MOUNTAIN SPLENDOR SERVICES, INC.
EL PASO COUNTY, STATE OF COLORADO
SITE DEVELOPMENT PLAN

SITE DEVELOPMENT PLAN

FLOOR PLANS

Subject: Text Box
Page Label: [1] MaineLaneDP-Floor Plan
Lock: Locked
Status:
Checkmark: Unchecked
Author: dsdseigny
Date: 5/7/2018 10:50:24 AM
Color: ■

FLOOR PLANS

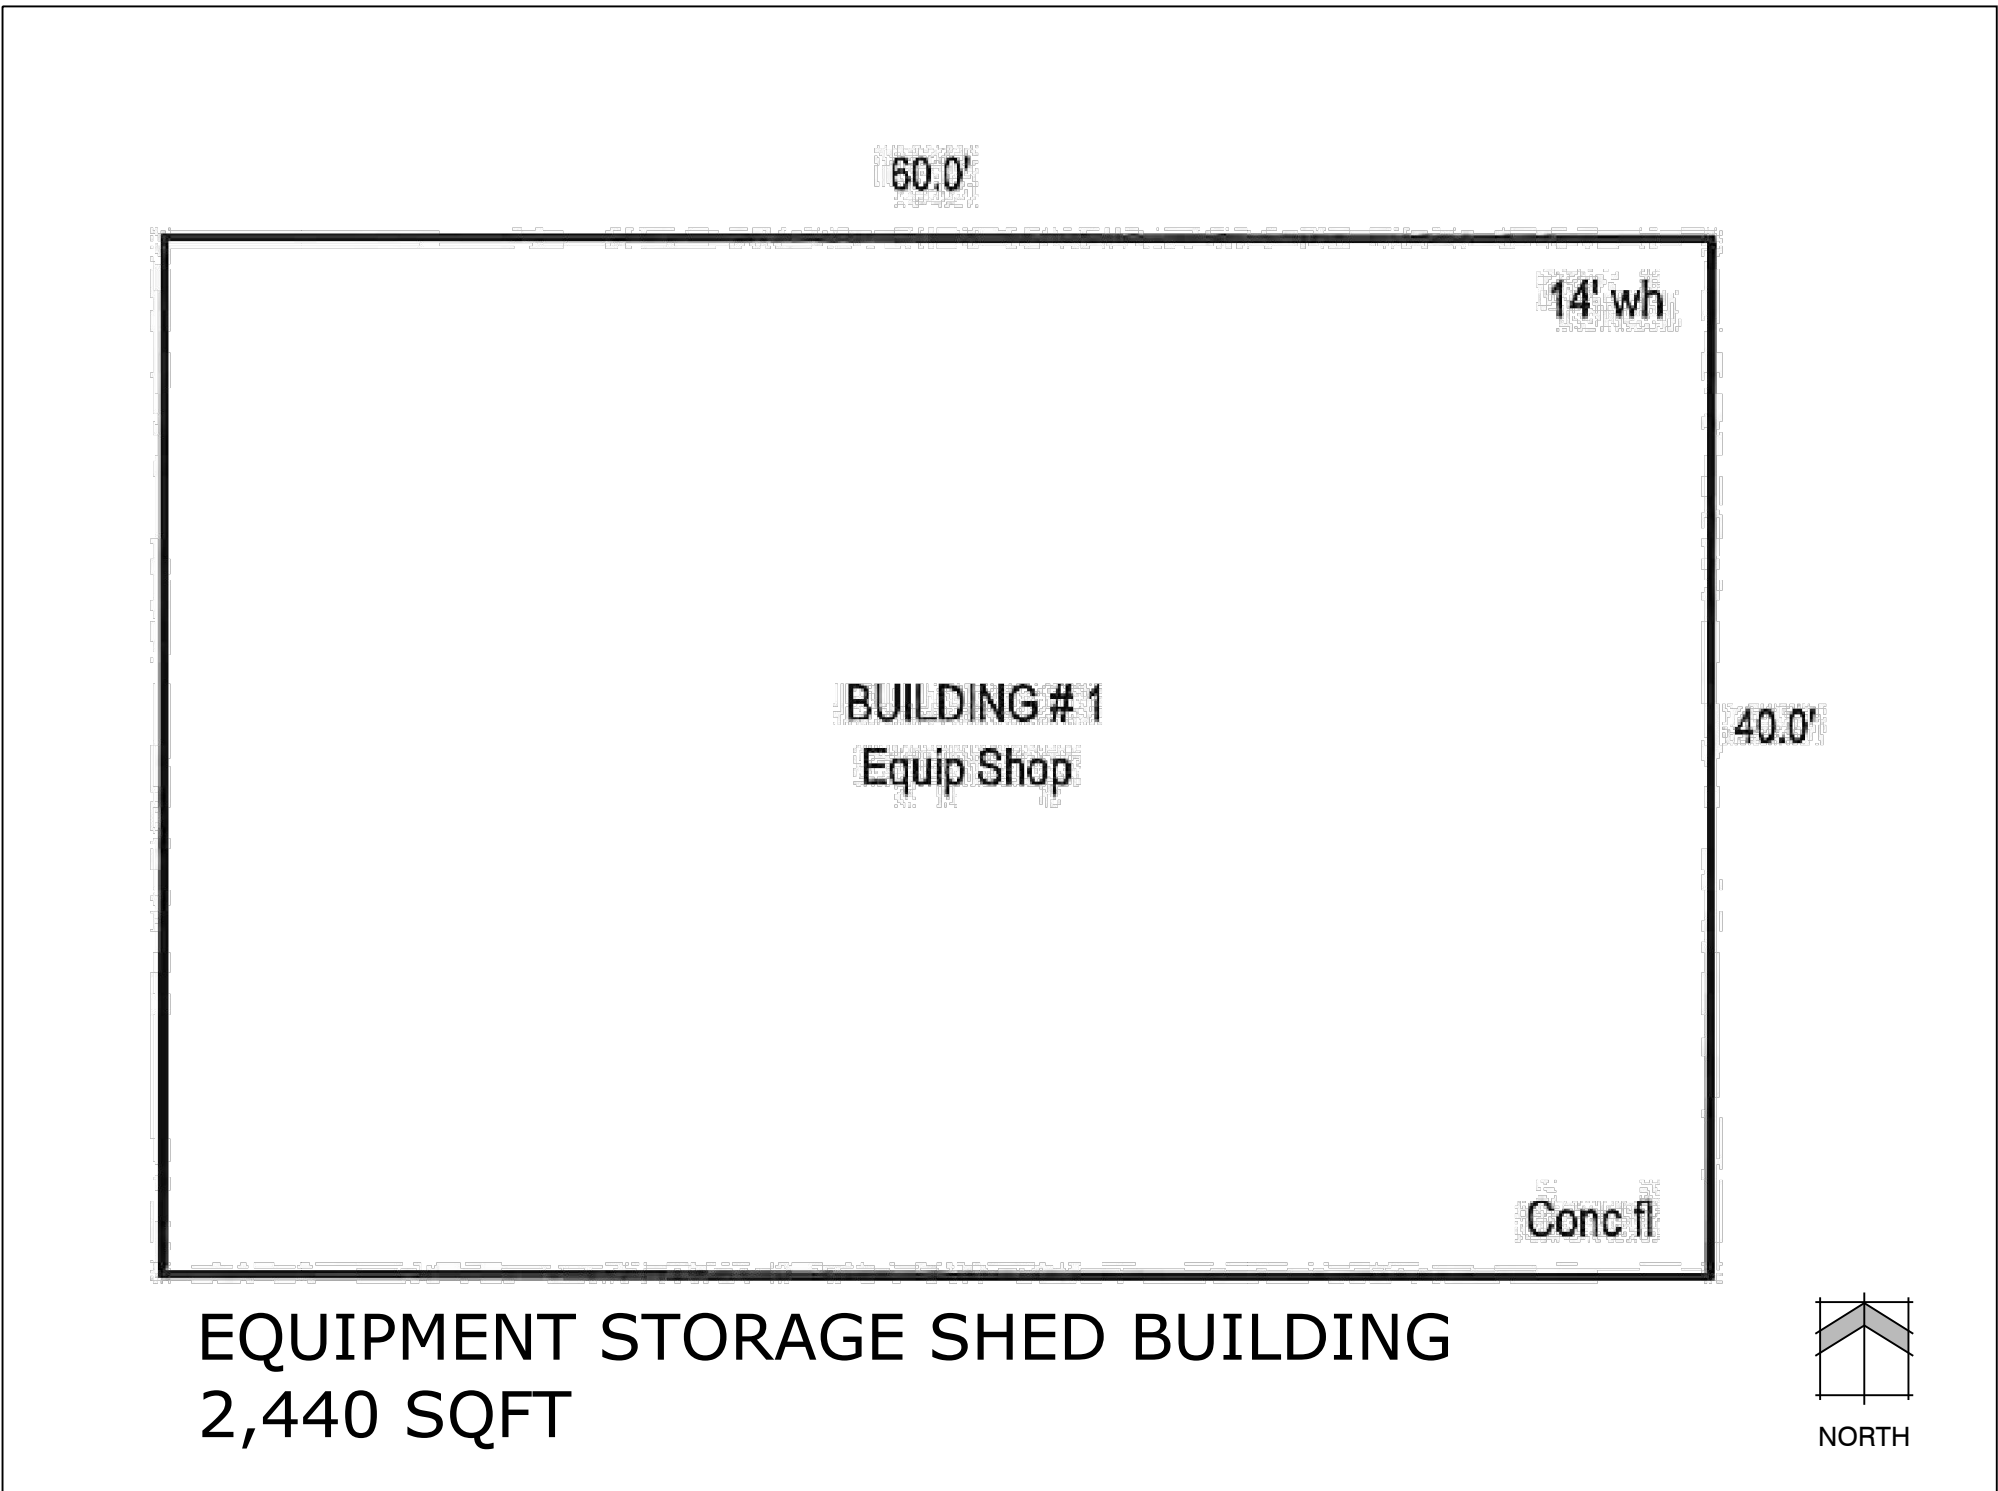
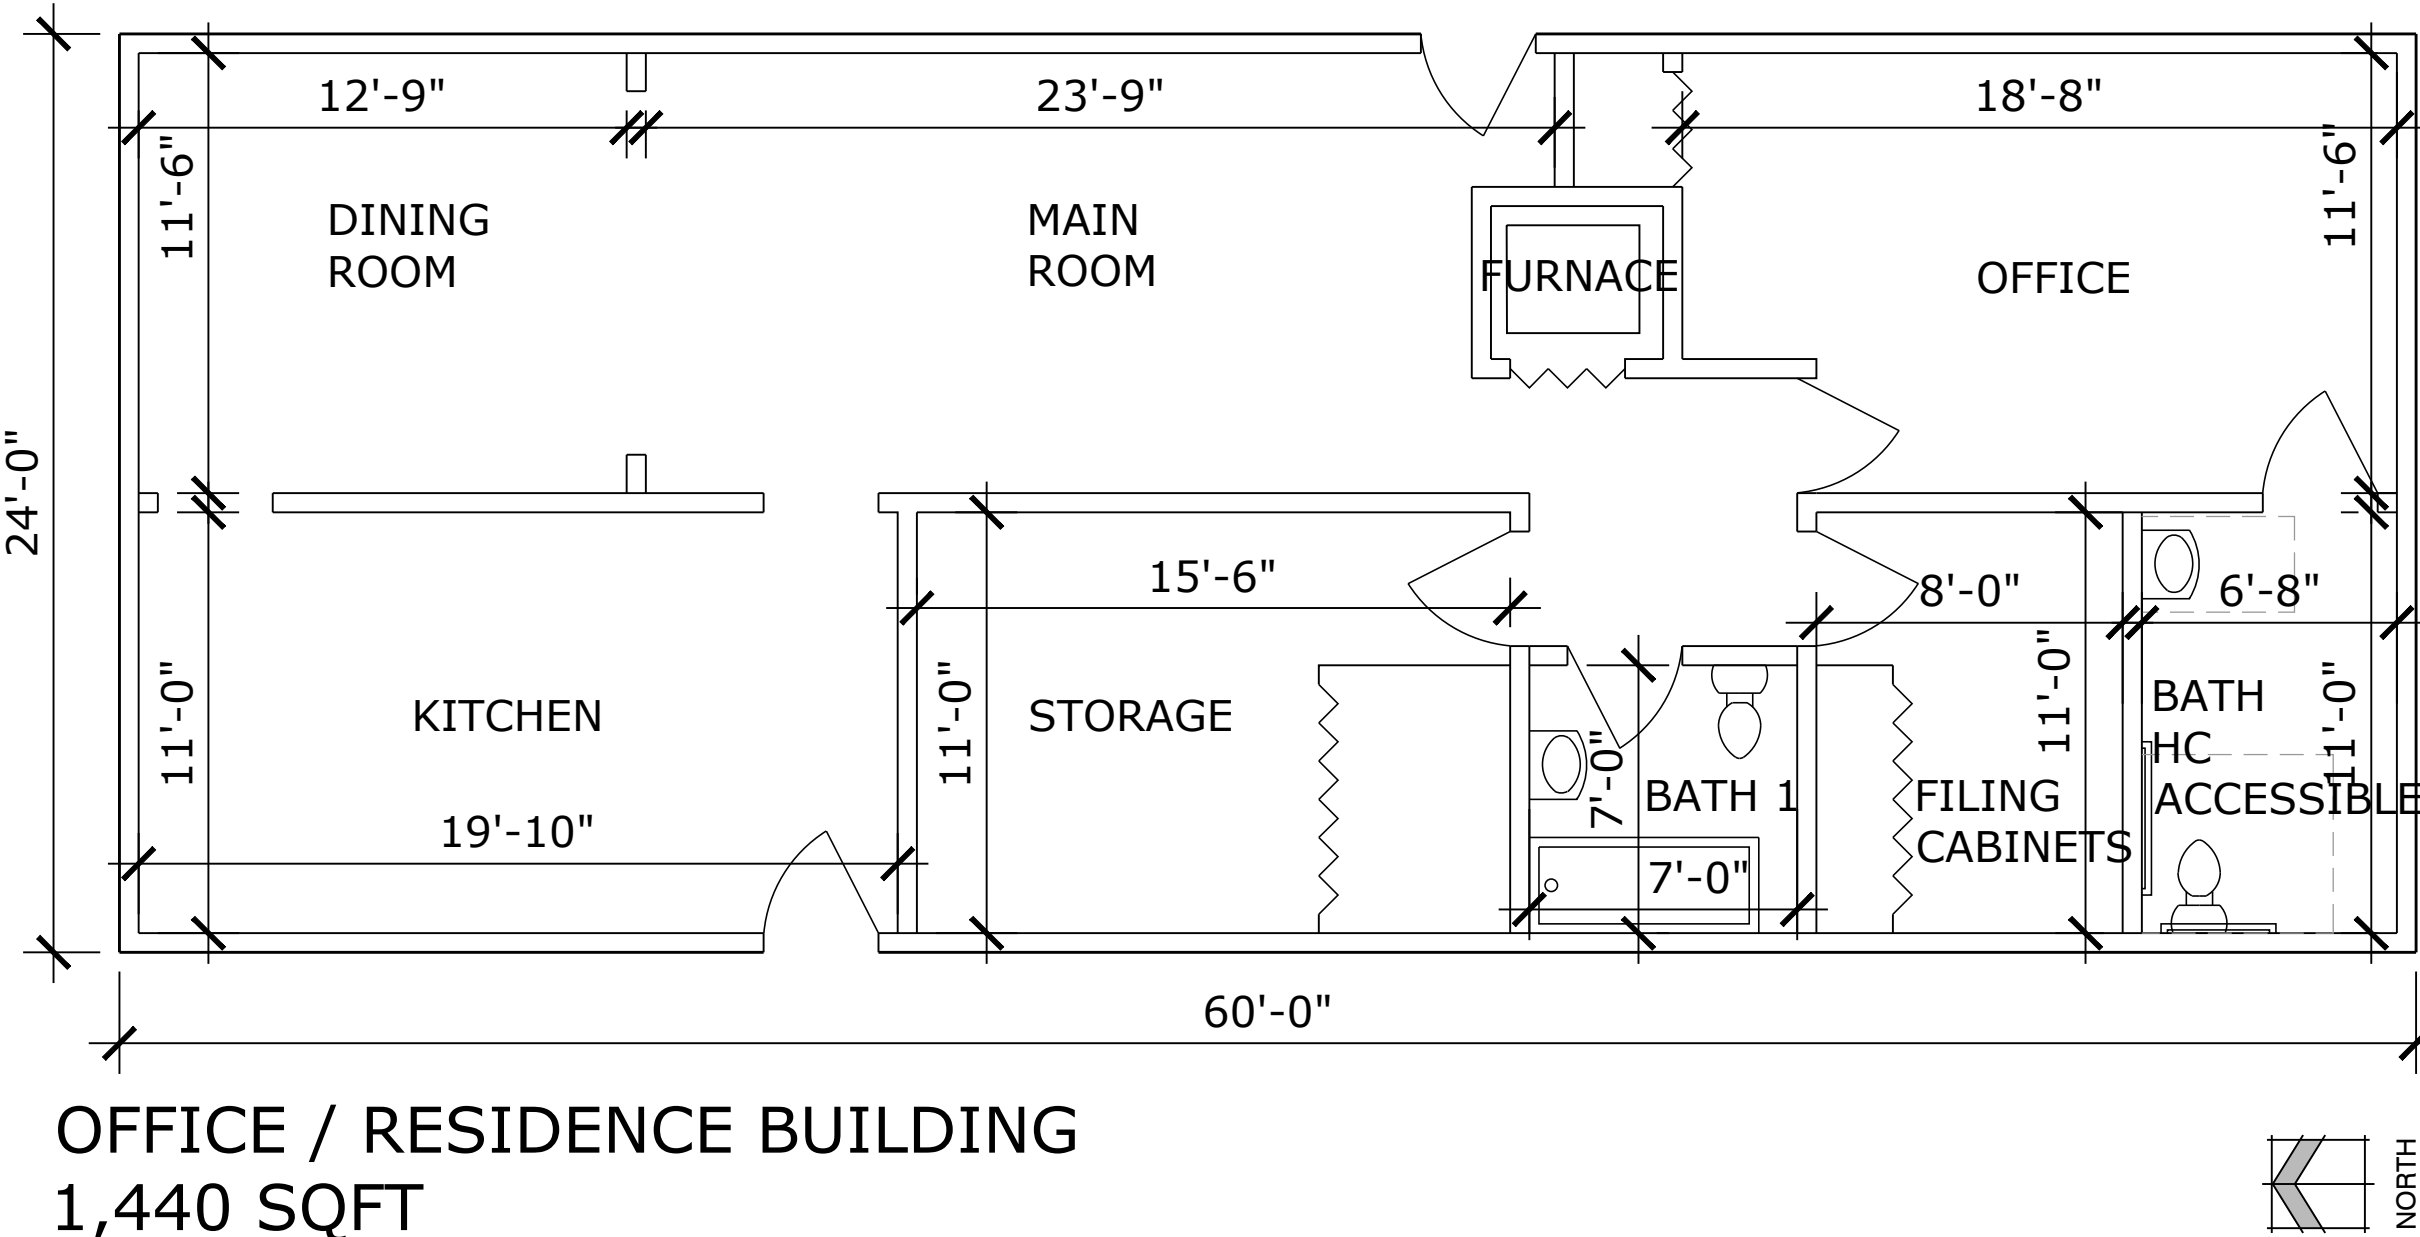
This is the site plan, not a floor plan of the structures. The floor plans should indicate the square footage of each structure, locations of office space, warehouse, bathrooms, etc. The well permit and OWTS system is only provided for the main structure, the floor plan needs to show if there are bathrooms inside the accessory structures.
